File: SF15/20035
Job ID No: DOC15/520531
Your Ref: SSD7056

RE: Exhibition of State Significant Development for Remediation, Restoration and Adaptive Re-Use of Campbell's Stores, 7-27 Circular Quay West, The Rocks (SSD 7056)

The Heritage Council Approvals Committee considered the matter at its meeting on 3 February 2016 and resolved to recommend the following conditions of consent:

03 HICKSON ROAD / SOUTH-WEST ELEVATION
SCALE 1:50

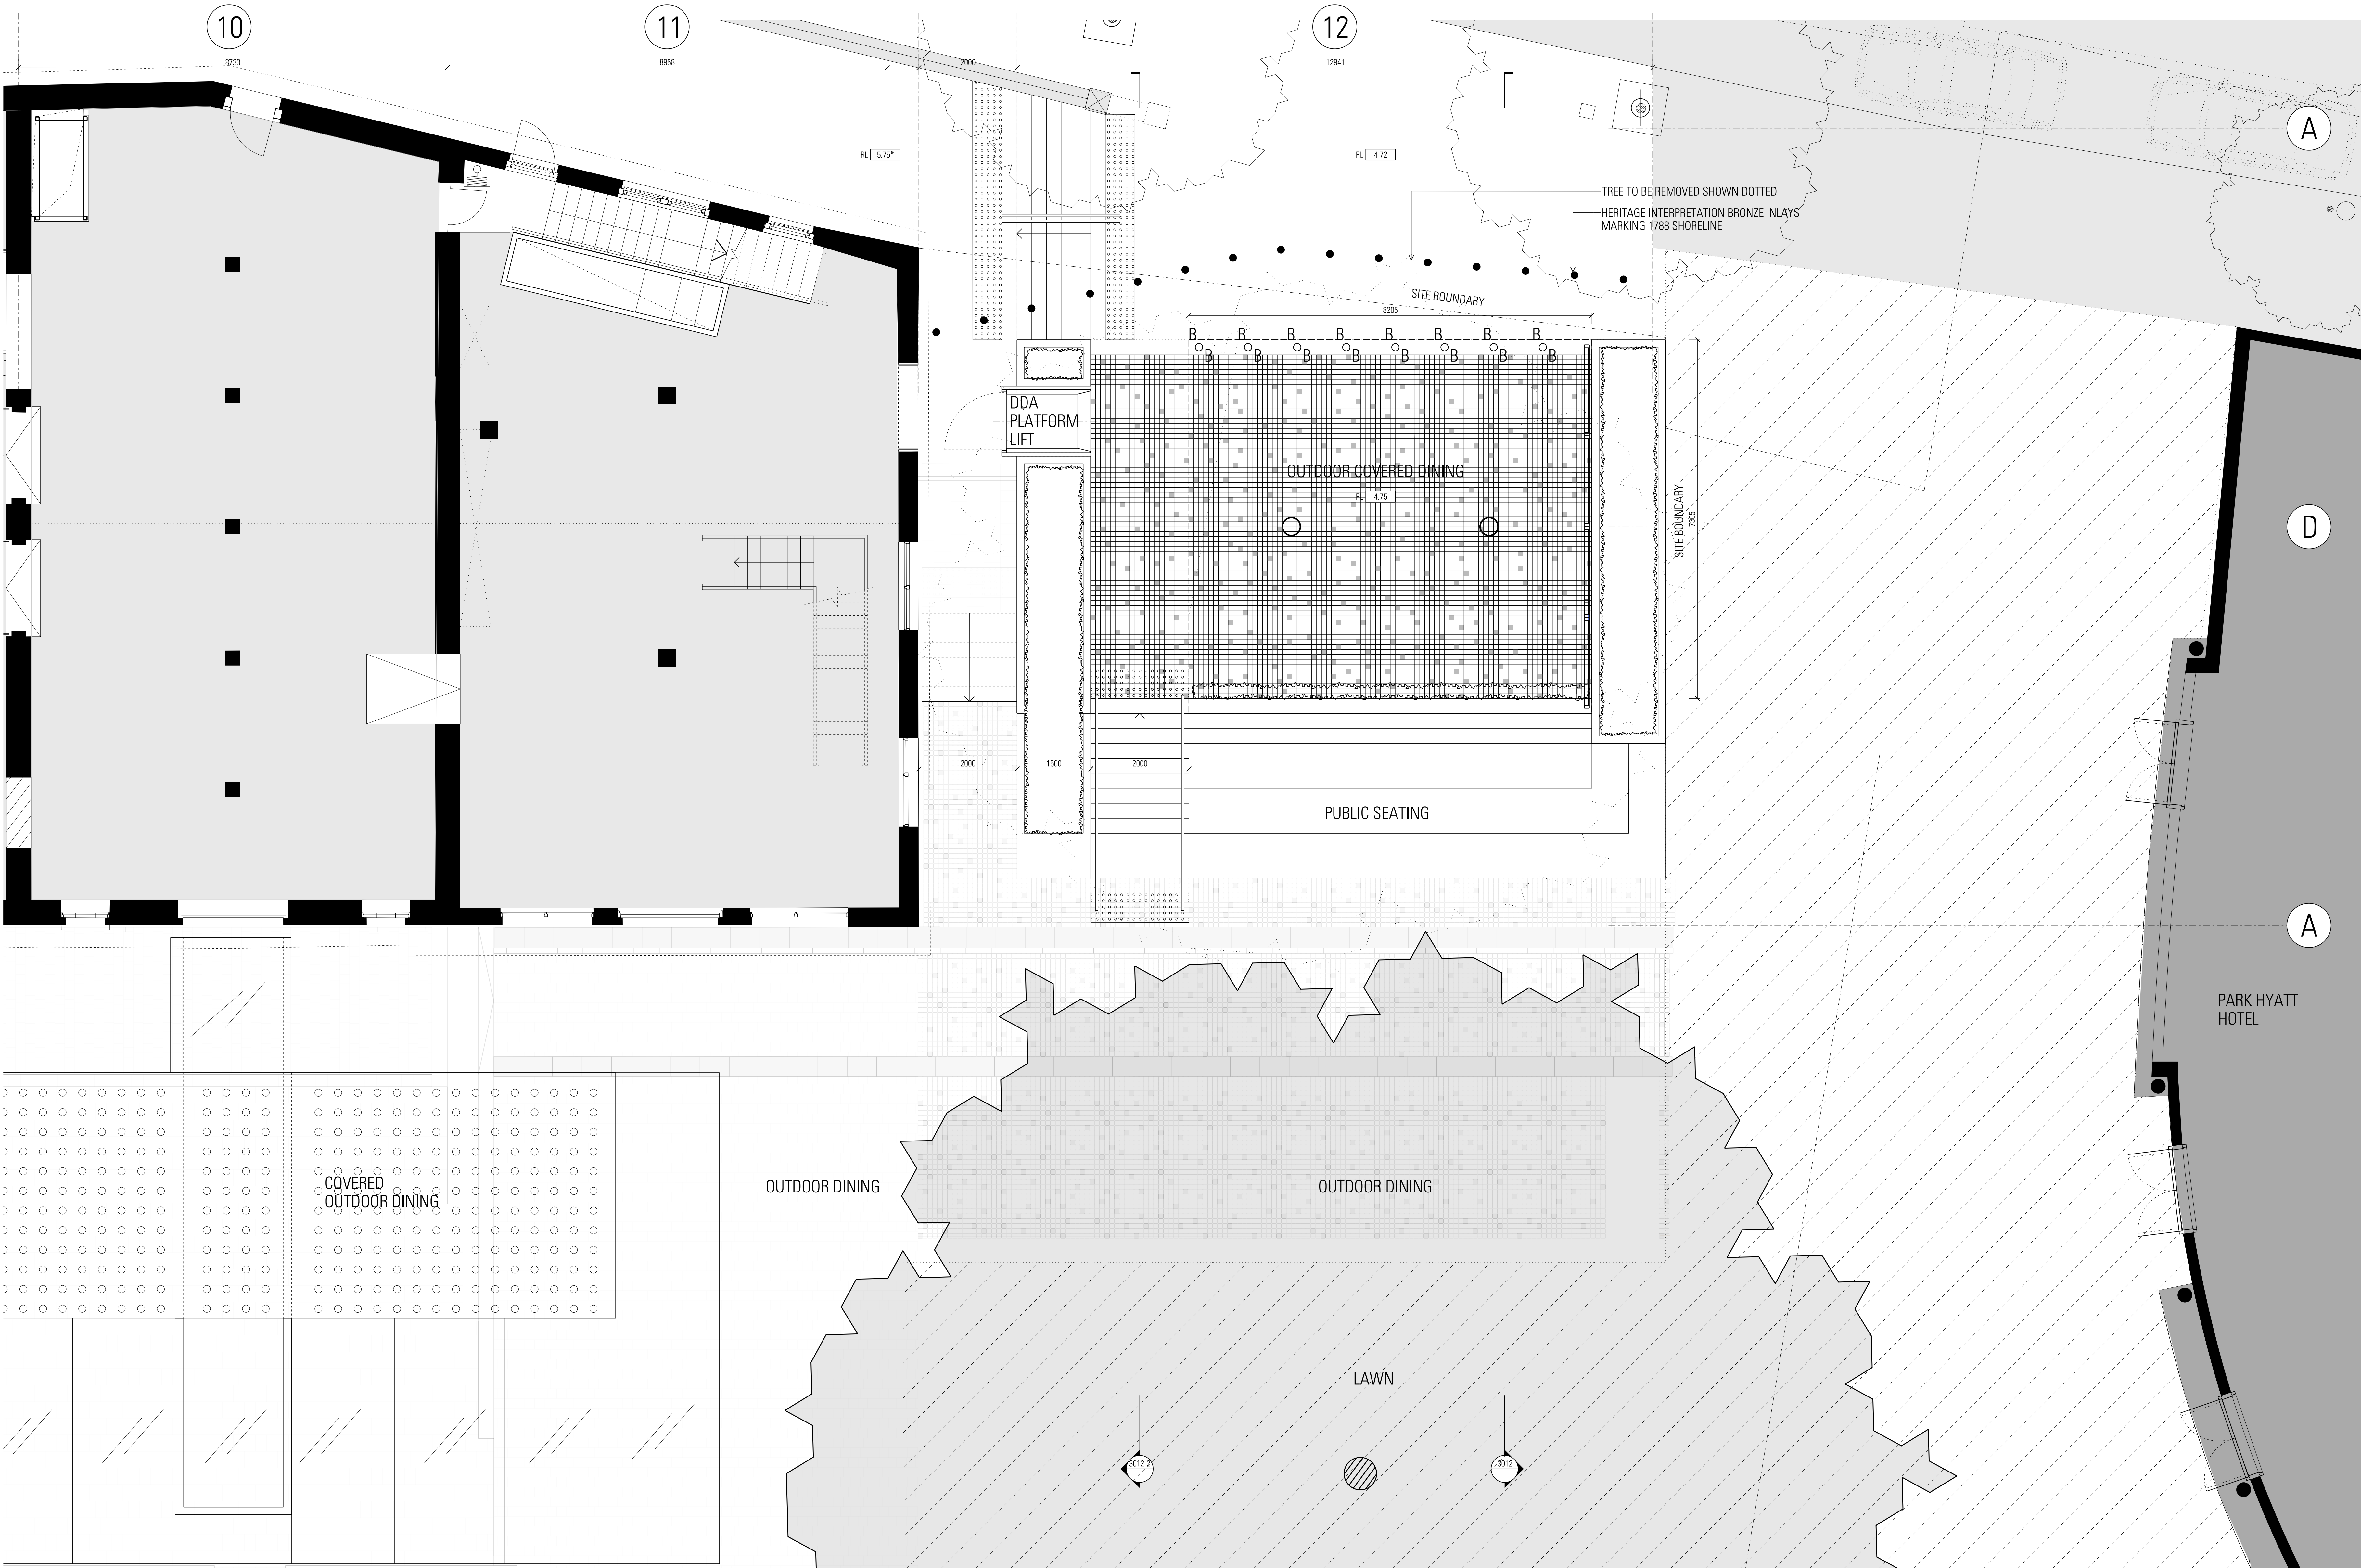
1. The new doorways in Bays 3, 6 and 9 of the west façade propose the removal of significant fabric and addition of new contemporary awnings in three locations that would diminish the architectural character of the west façade from Hickson Road to an unacceptable level. It is recommended that approval is granted to Bay 6 only as this is the public bay and would be symmetrically placed.
